OBJECTION

State Significant Development Application No: SSD-10300

Coffs Harbour Cultural and Civic Space

RIDING LANE ELEVATION

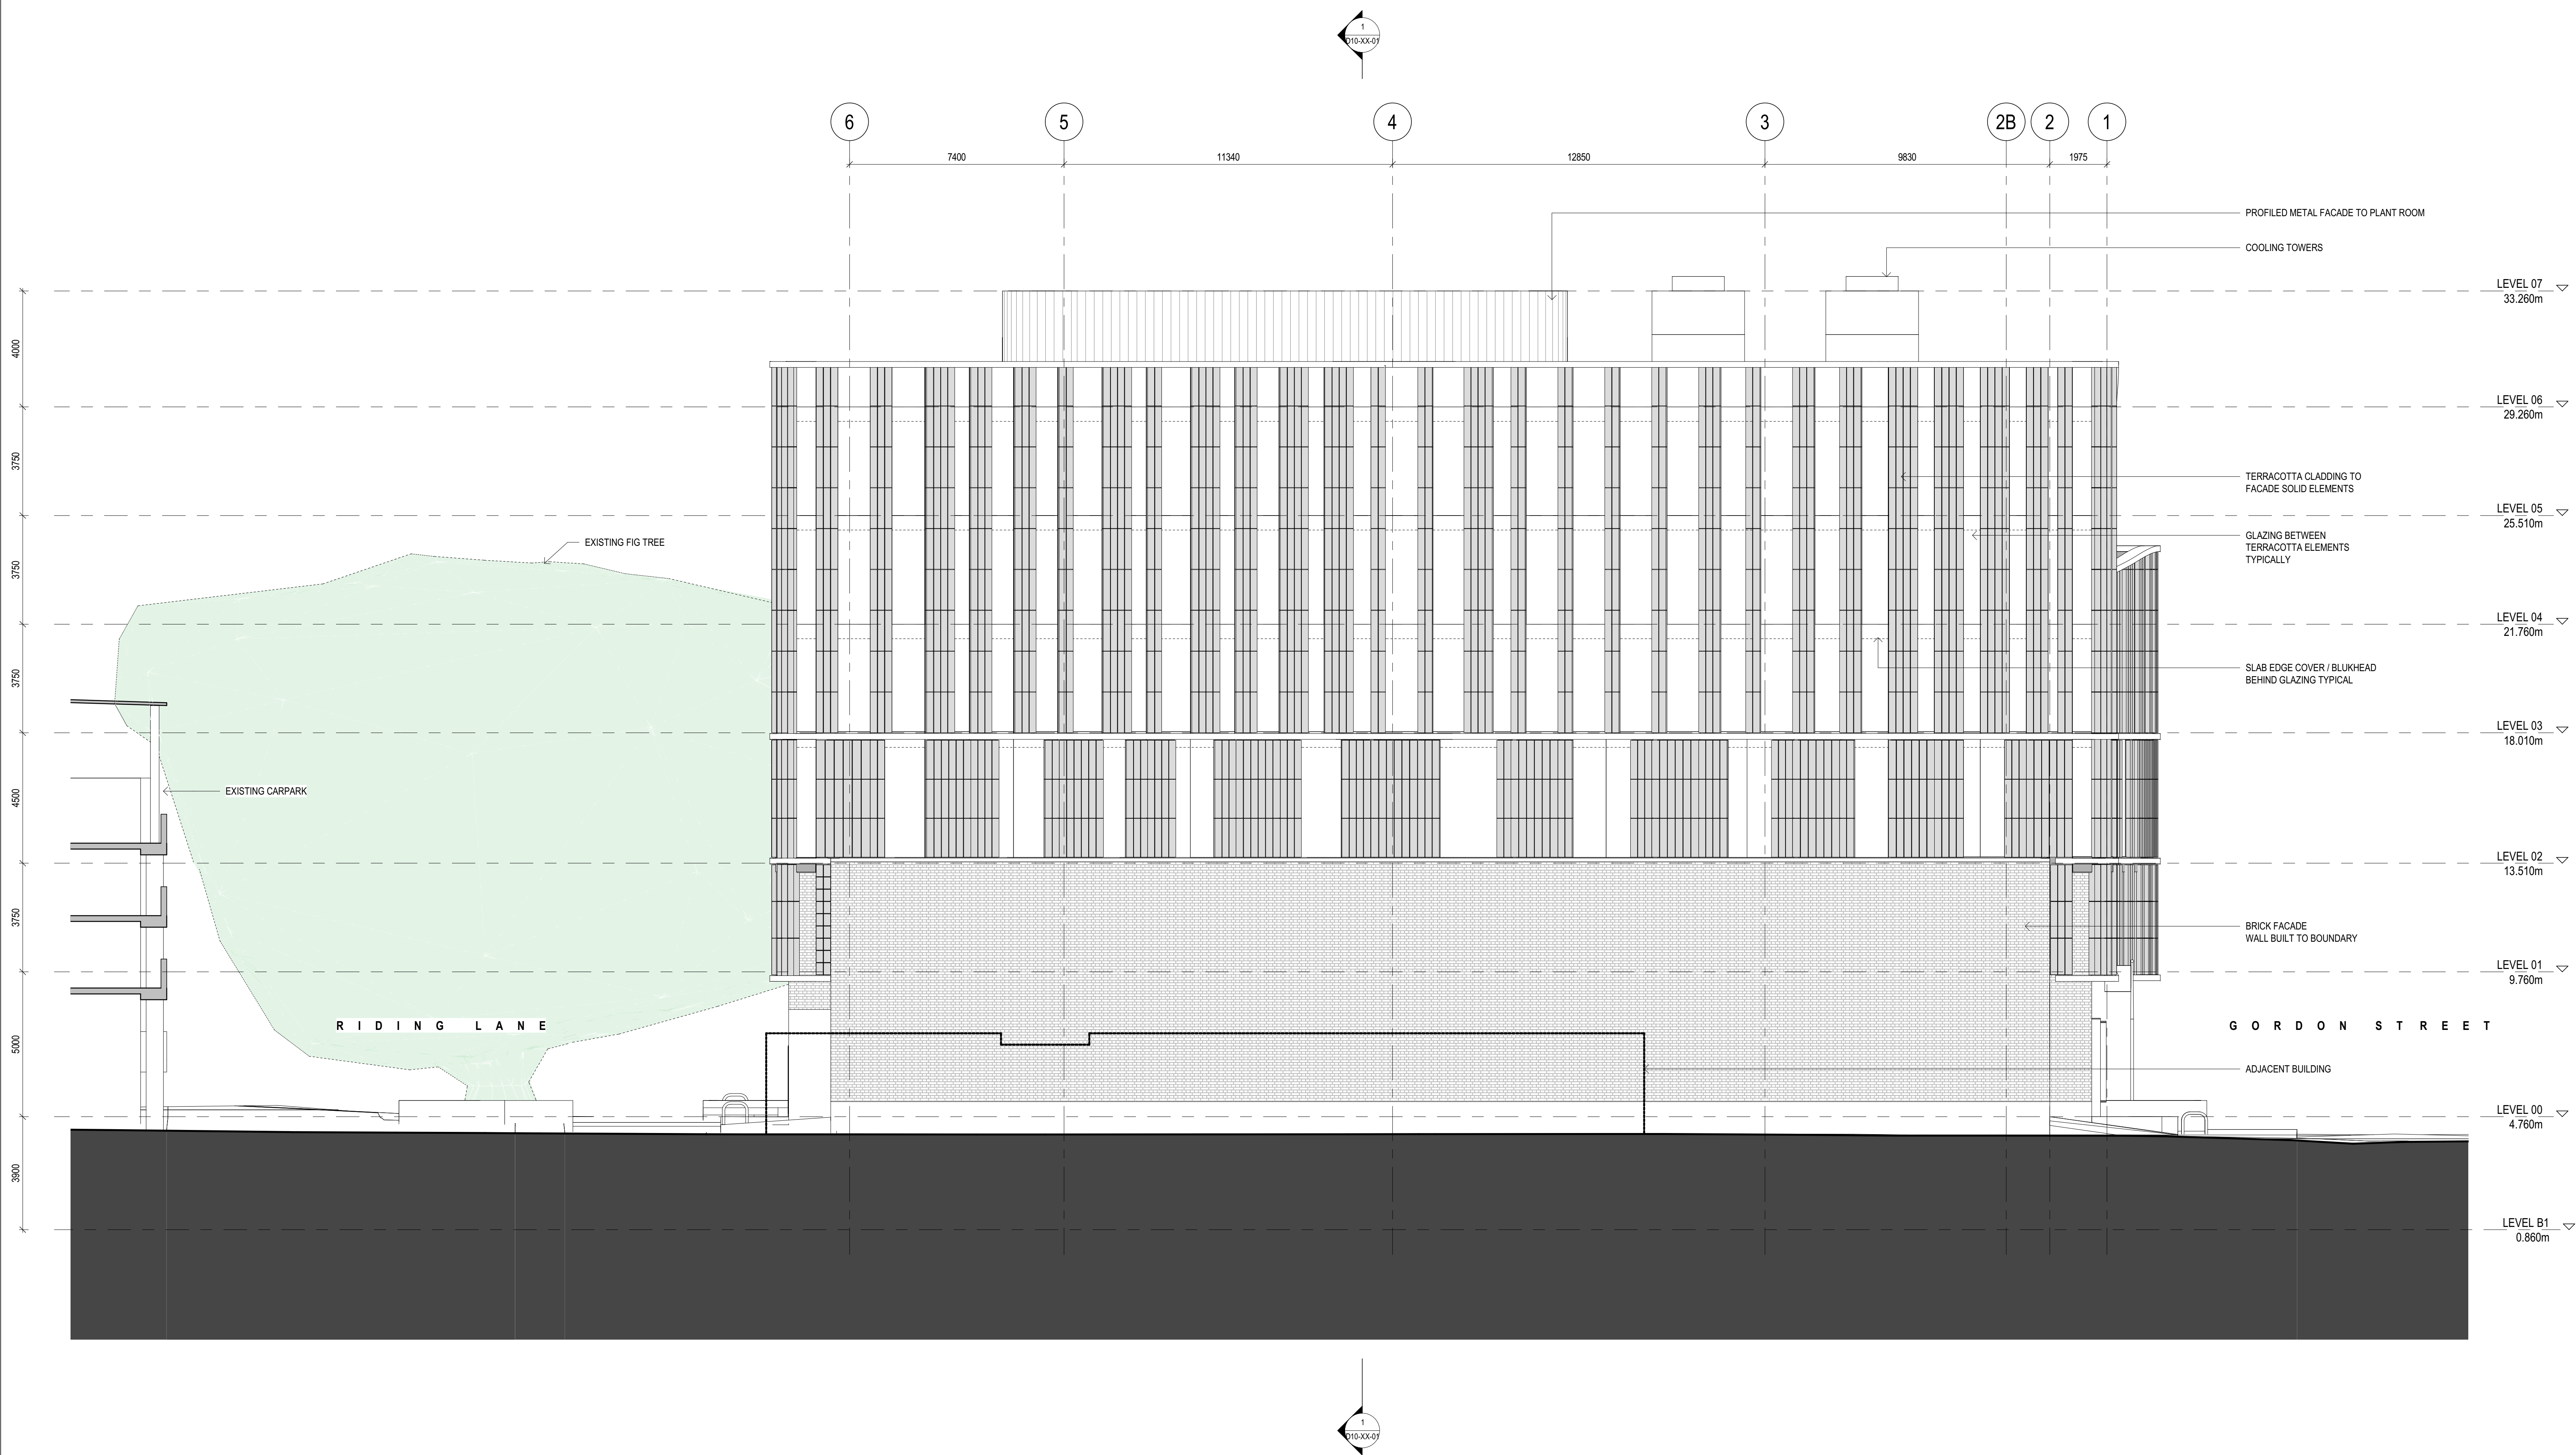
6. The proposal does not meet "safer by design" principles and guidelines, as the arcade to Riding Lane confuses boundaries and provides "hides" for criminal activity, vagrancy and prevents good surveillance.

SECTION N-S

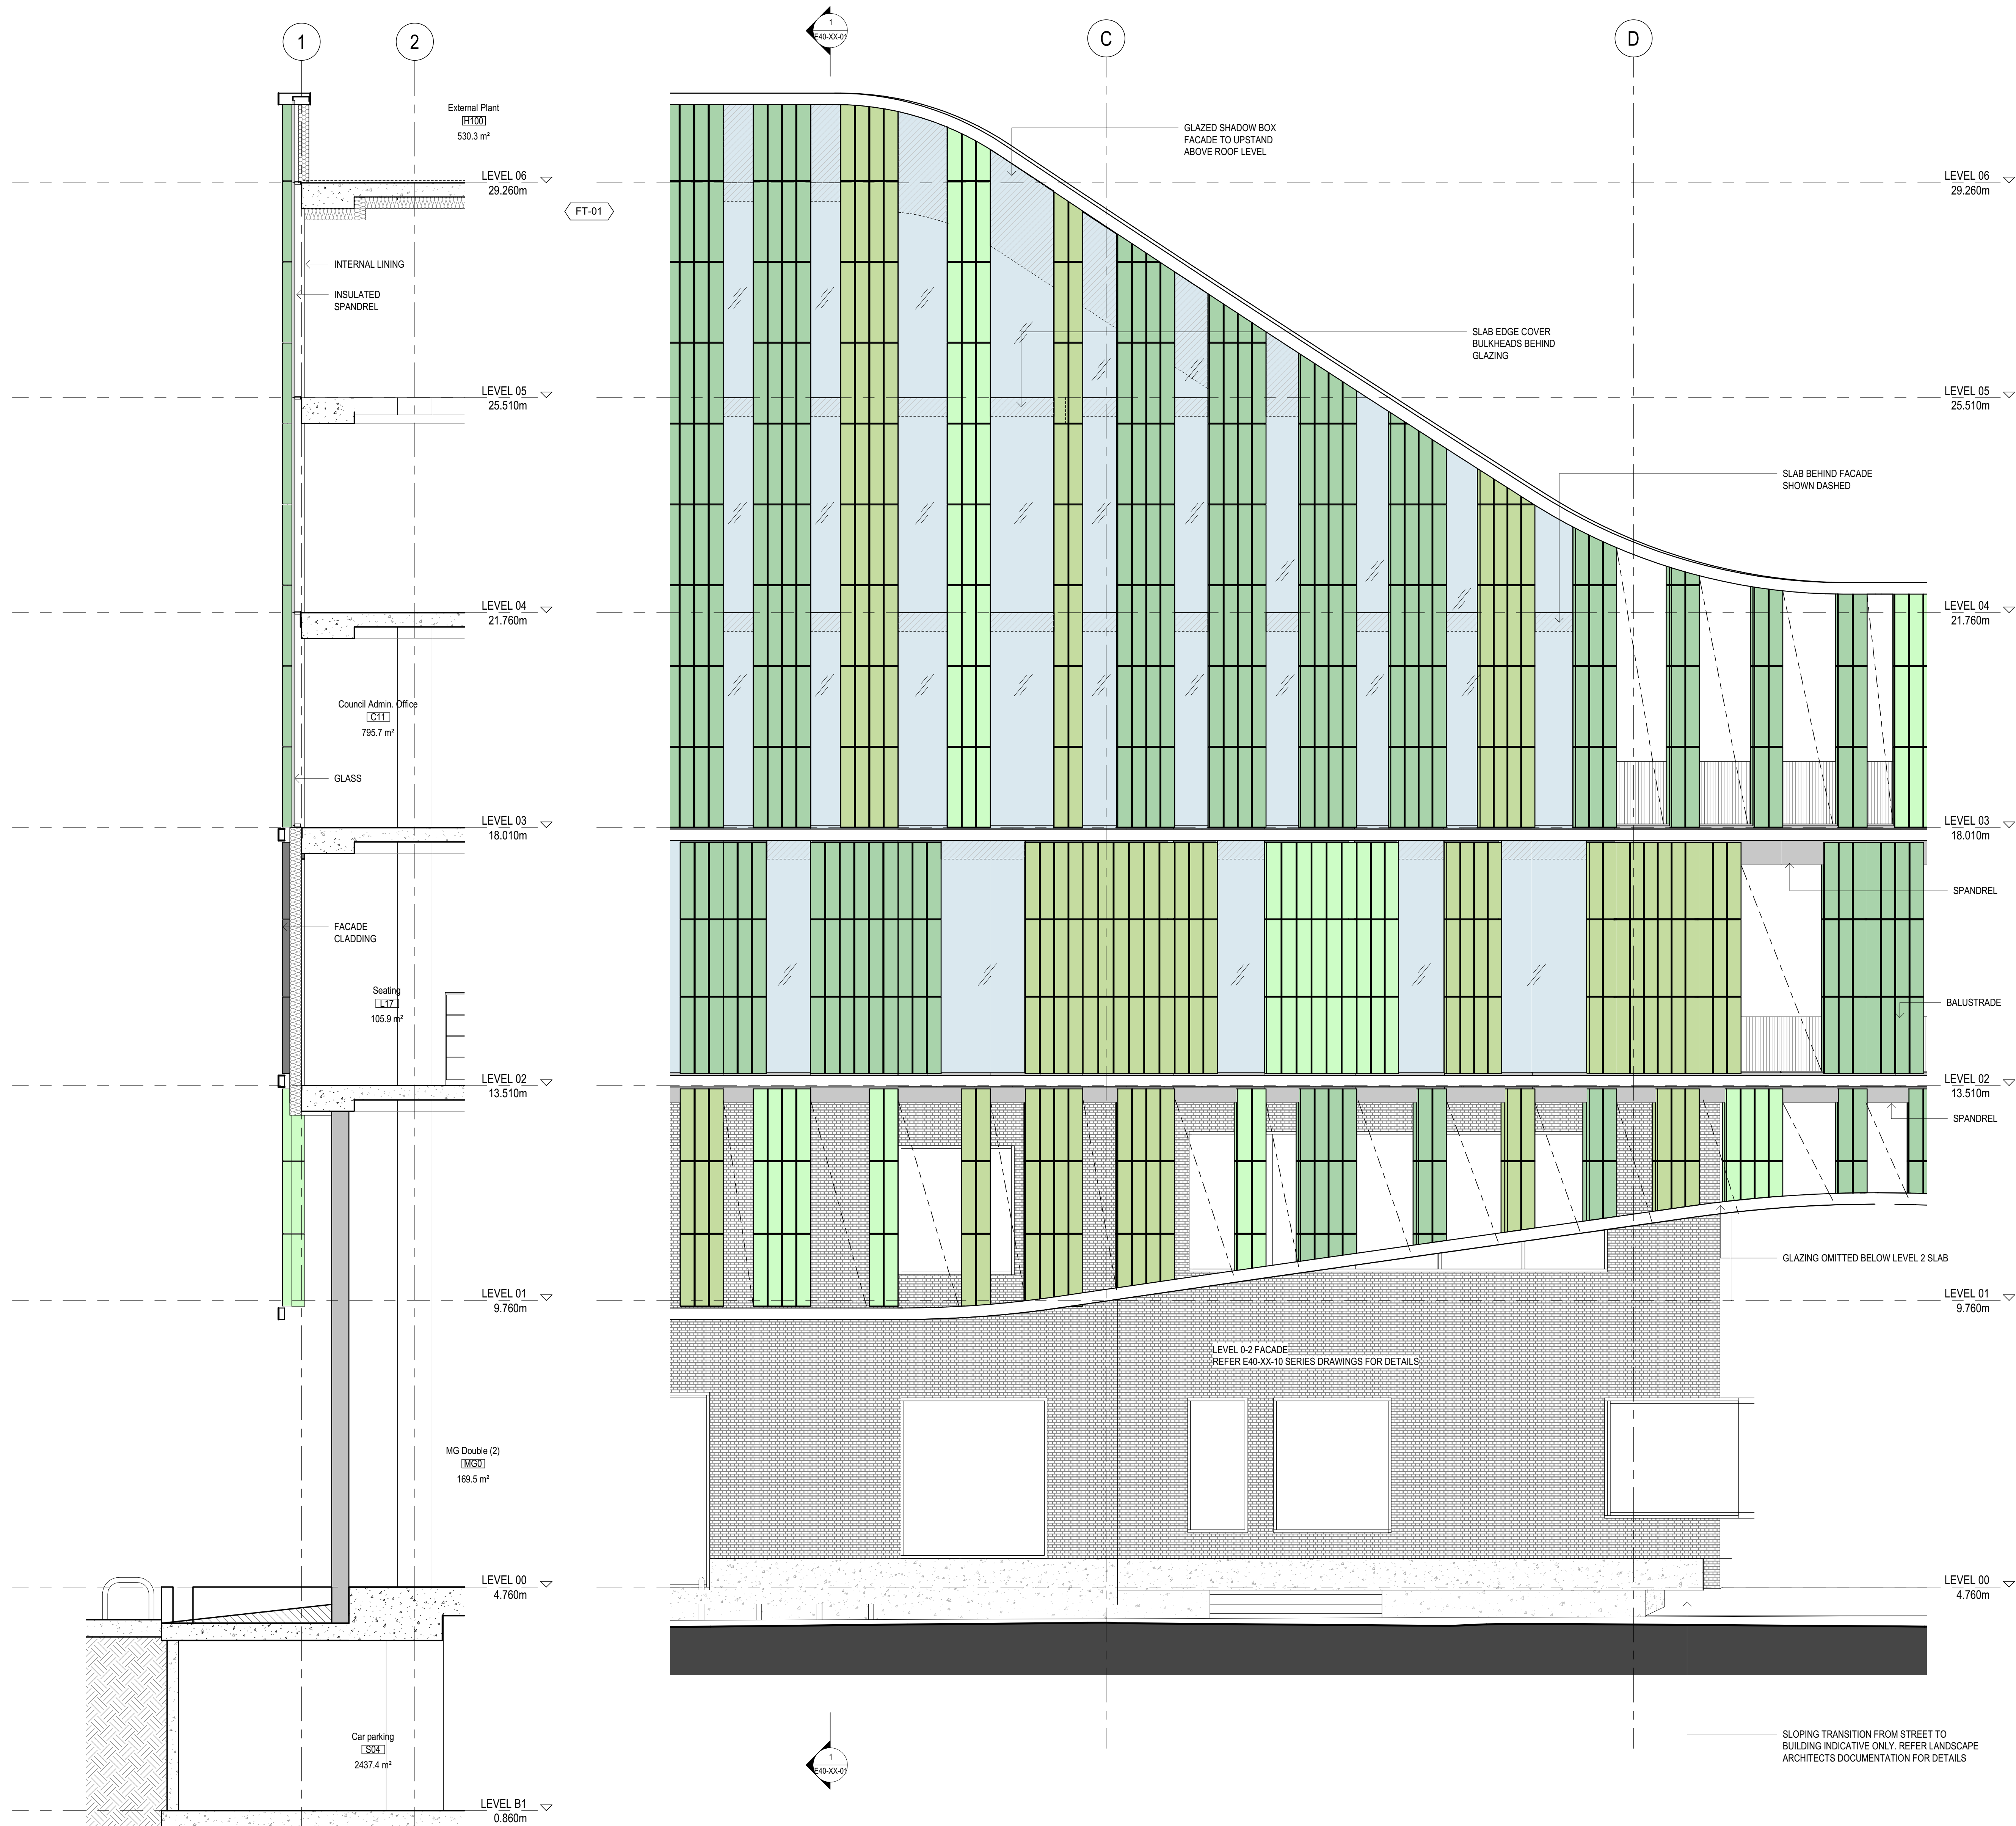
7. As a public building it fails to provide sufficient climate protection for pedestrians during storms and summer sun.
8. The building exceeds the height restriction of 28m set down in Council's own planning controls. Council's argument for variation is not satisfactorily justified and is not consistent with the objectives of the Environmental Planning and Assessment Act 1979, which requires the "the orderly and economic use and development of land". Council should not receive preferential treatment.
